Additional Items to be Addressed Prior to Intake

Ke:	spon	ses in Red Belov	N:								
	INTAKE COMMENTS  CST  Revi Ema Stat											
					Intal	ke#						
DATI	E		TIME					PERMIT #				
Proje	ect Ad	dress	·									
	icant							Owner				
Scop	e of W	Vork										
CITY	STAFF											
CUST	OME	R SERV	ICE TEAM (CST)	LAND USE	E PLAN	NNING (L	.UP	)	BLDG F	PLANS EXA	MINER (BL	D)
EIDE	DEVIE	\A/ED /I	IDE)	CIVII SITI	E LITI	LITIES IC	11/11	1	TDEEC	/TDEE\		
FIRE	KEVIE	WER (I	-IKE)	CIVIL, SIT	E, U I I	LITIES (C	IVII	-)	TREES	(IKEE)		
						CST		LUD	BLD	FIDE	CIVII	TDEE
ACCI	PTED					CST □		LUP	BLD	FIRE	CIVIL	TREE
			OVAL REQUIRED PRIC	R TO INTA	KE							
			AKE SCREENING REQU									
*ADI	OITION	IAL SC	REENINGS ARE CONDU	JCTED BY A	NPPOI	NTMENT	10	NLY. PLEAS	E SCHEDU	LE WITH C	ST STAFF.	
Form	natting	of Fle	ectronic Plan Set									
			l plan sheets into one	Single PDF	file.							
			applicable:									
		Surve	y 🔲 Site Plan	☐ Arcl	hitecti	ural She	ets		Structural	Sheets	Civi	Sheets

A. FRONT (SOUTH) ELEVATION  
1/4" = 1'-0"

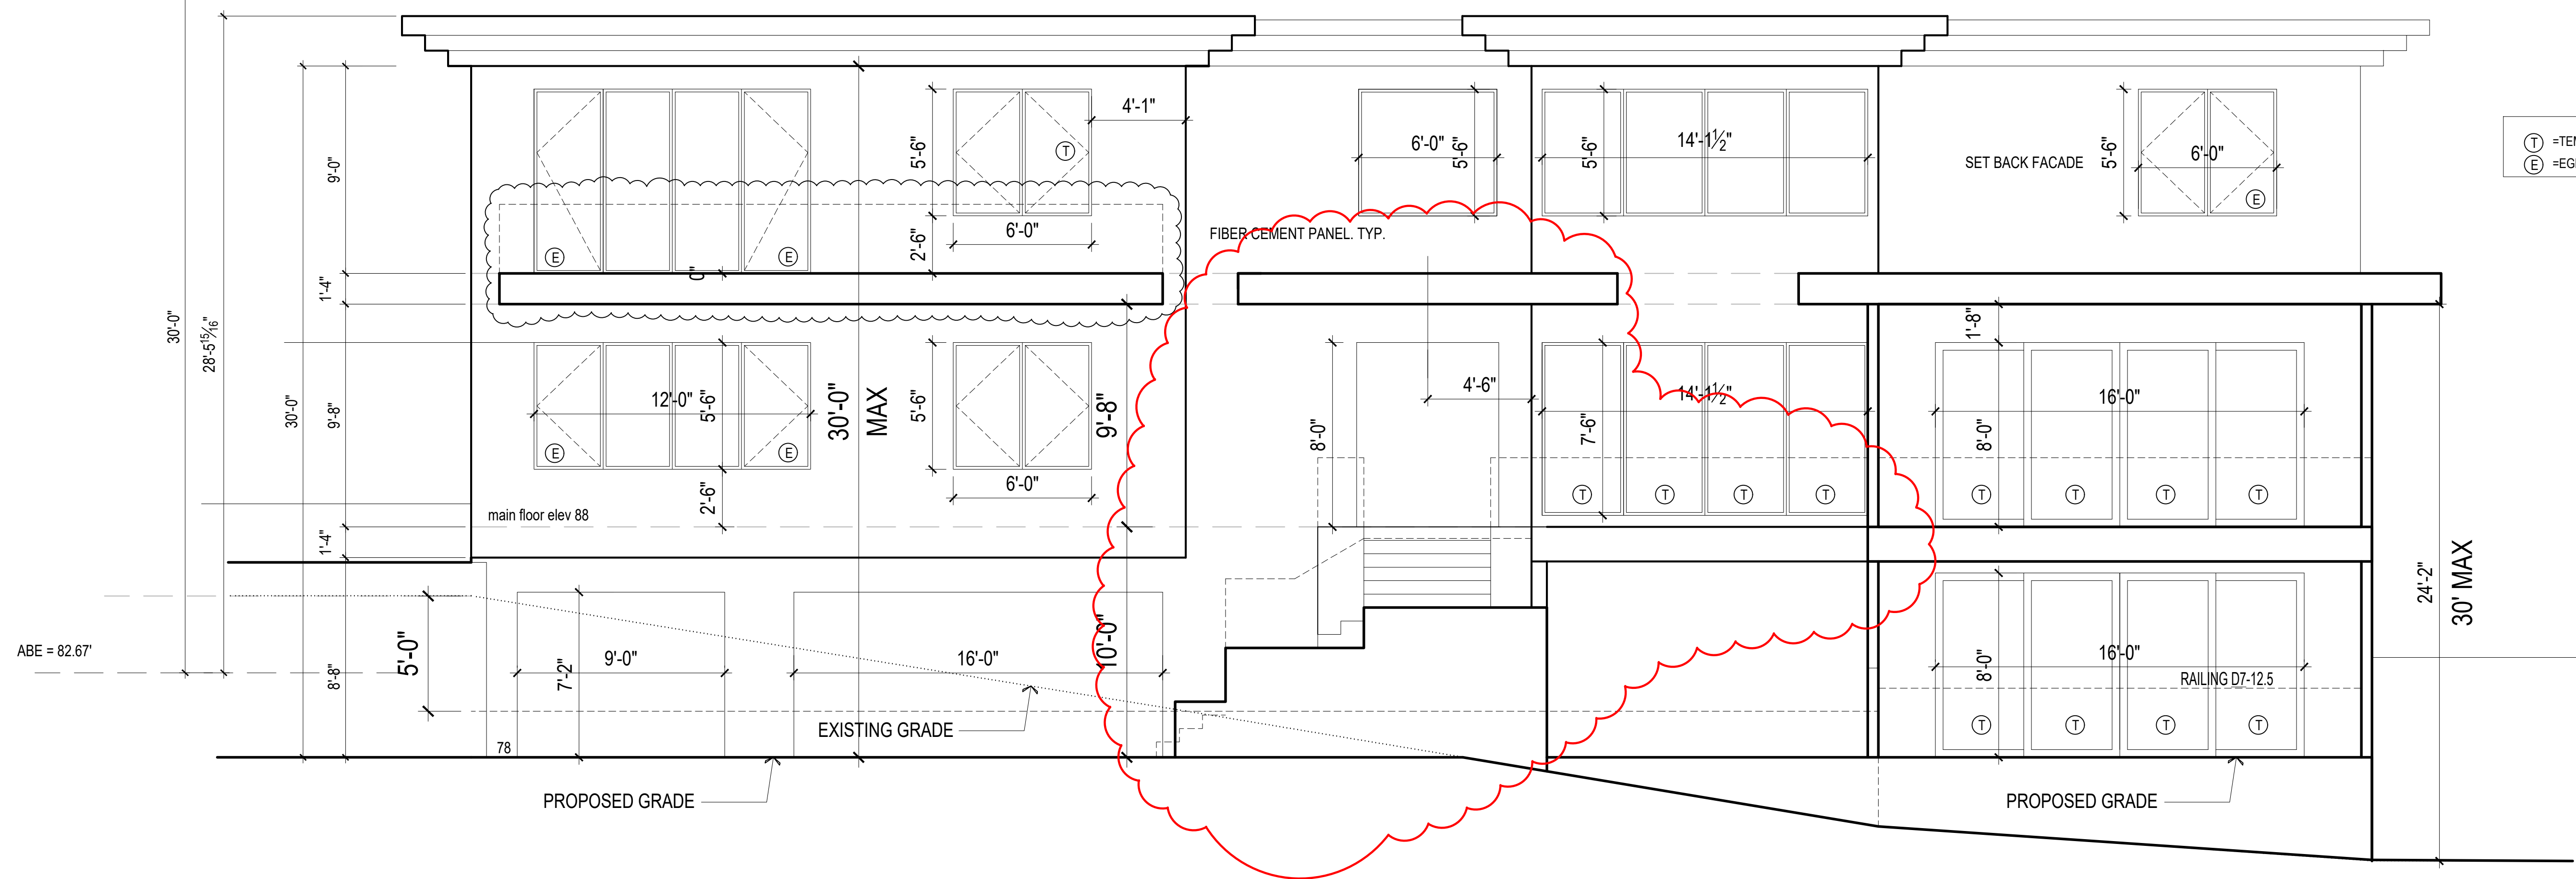
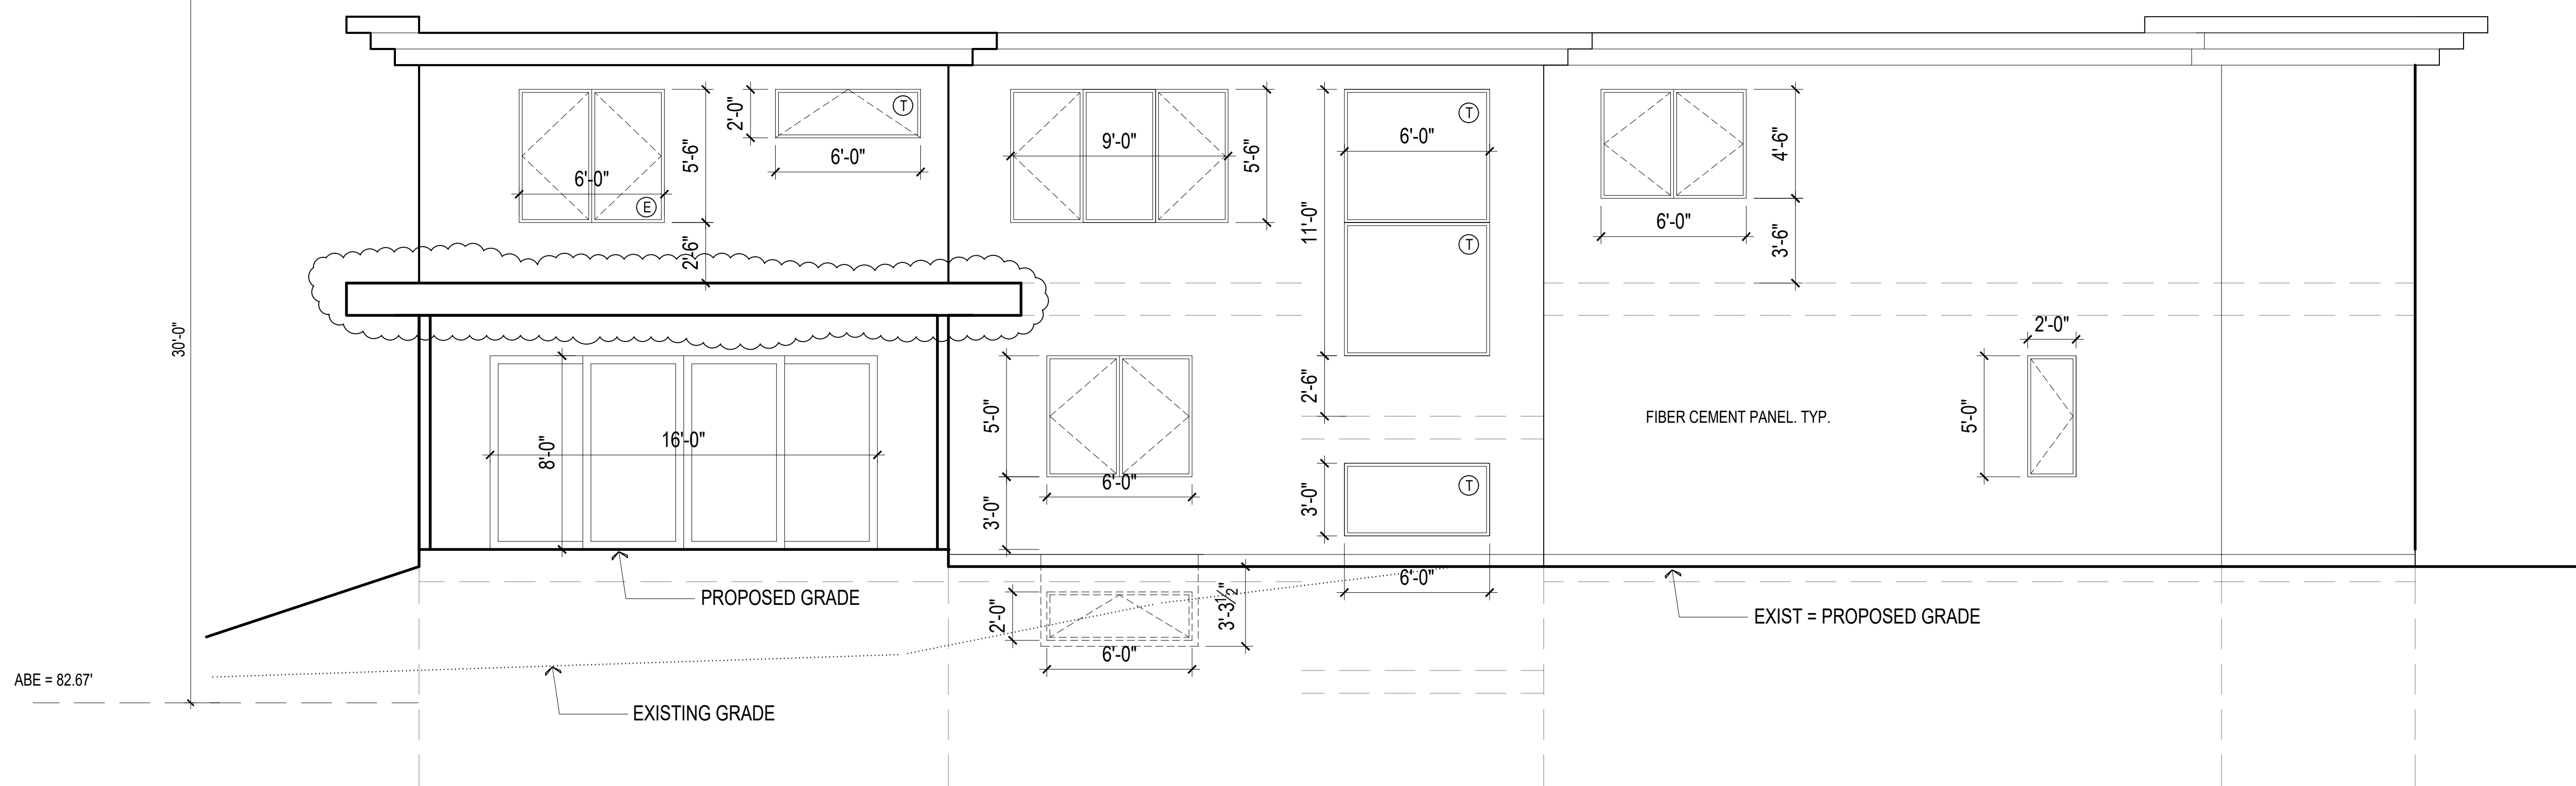
INT	ΓΑΚΕ	COMMENTS Reviewer									
	DI	ANNING Email									
	P L	Status									
	1	actions Required									
	1	reline Permit									
		cal Area Review 1									
		cal Area Review 2									
	Envi	ronmental Review (SEPA Checklist)									
	Acce	ssory Dwelling Unit (ADU)									
	Lot L	ine Revision									
	Othe	er									
Surv	eys R	equired Prior to Final Inspection									
	A bu	ilding height survey is required prior to final inspect	ion								
	An ir	mpervious surface, lot coverage, and or hardscape s	urvey i	s required prior to final inspection							
	A pro	operty line/setback survey is required prior to final i	nspect	ion							
Perr	nit Se	t Drawings									
	Site										
		Lot size and slope		Provide land use zone (R8.4, 9.6, 12, 15)							
		Provide site address		Indicate location of ADU and entrance							
		Indicate property lines and dimensions		Topo/boundary line survey							
		Indicate building dimensions		Provide a site plan to scale (1" = 10 'minimum)

ADD	ITIONAL COMMENTS
	ok
	OK .
	ok
	OK, absolute height provided, I will note relative height on plans as well.
	In doing so I noticed I had a wall over 6' in the side yard setback, so I
	made an adjustment to the plan.
	OK
	OK
Note	s to DSG Staff For Internal Use Only–No Applicant Response Required

**PILE AND GRADE BEAM PLAN**

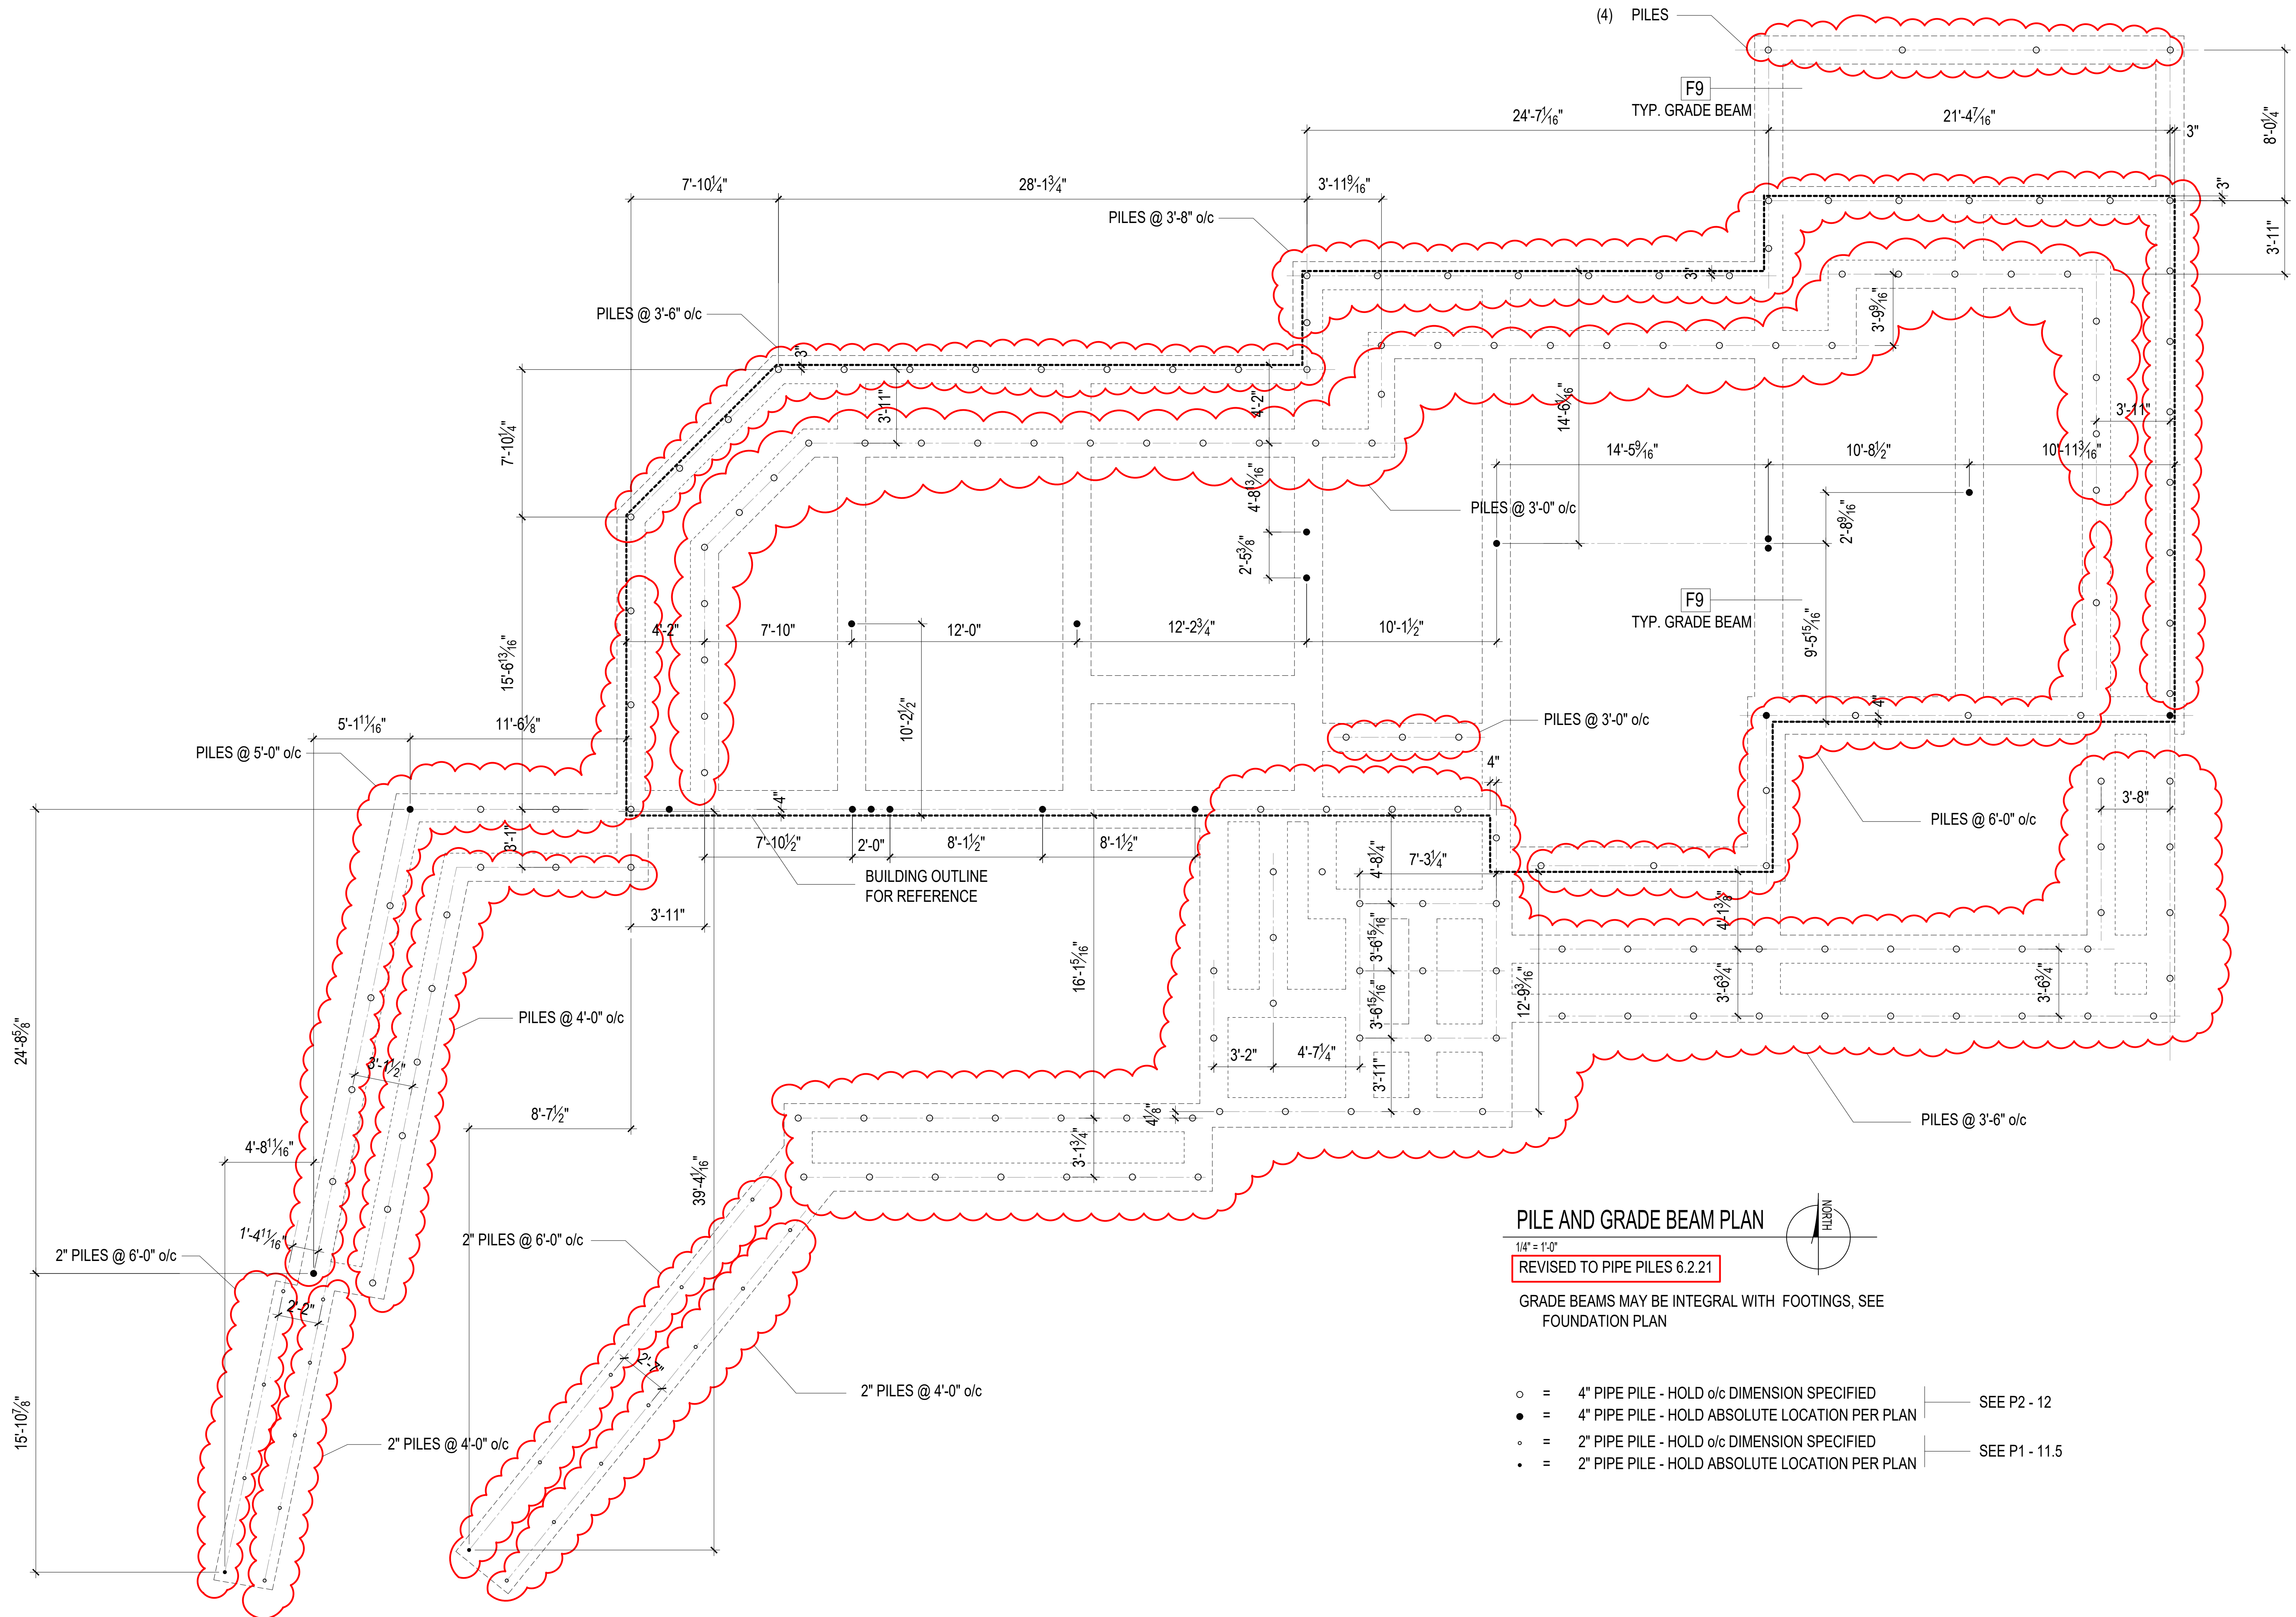
Site	plan	indicating exten	t of propose	ed work		
	Limi	its of	excavation durin	g construct	ion limits noted on sheet 15, I will transfer to the site plan		
	_		structural notes				
	Fou	ndati	on plans				
			ming plan for eac	h level			
$\vdash$			ning plan				
H				mponents (4	e.g. shear walls, holdowns, straps) on plans		
H	_		at least one build				
H					on with building components		
H			ouilding elevation		on with building components		
H	110	riue l	Junumg elevation	13			
H							
Ш							
	Fr.		ngineer:	المحاللة	and the designed as a samplification of the life
